Application for a non-material amendment following a grant of planning permission.

Two storey side extension and single store rear extension

Reference number:	AW/349/18/HH
Date of decision	31/01/2019

Tile hanging to front and side elevation to be replaced with grey timber effect (fibre cement) horizontal boarding

Proposed Extension and Alterations
at 5 Selsey Avenue, Aldwick
for Mr and Mrs C Simmonds
Drawing P01a November 2018 Scale 1:100 @ A3
Planning Drawing - Ground Floor Plan & Elevations

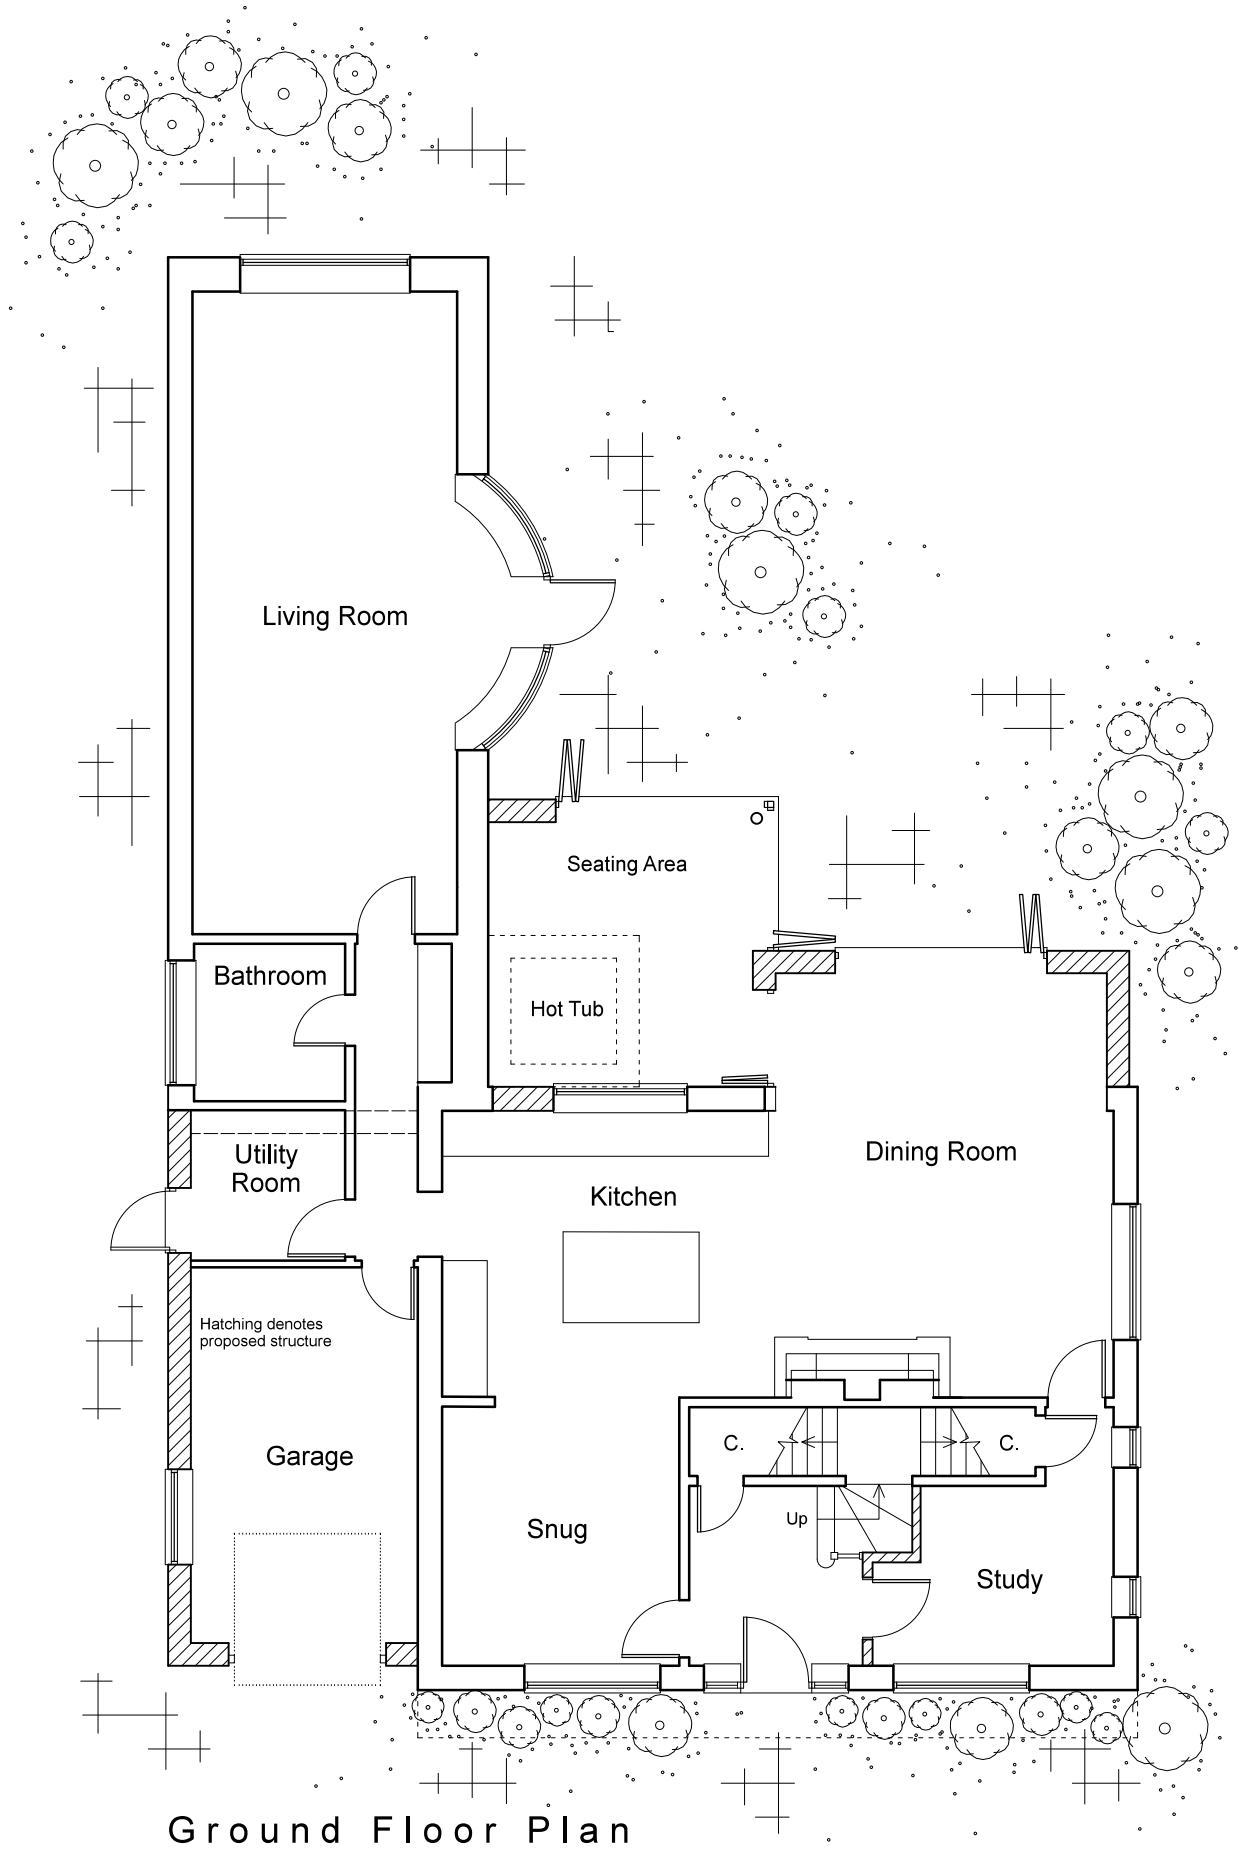
Drawing P01 & P02

Drawing P01a & P02a
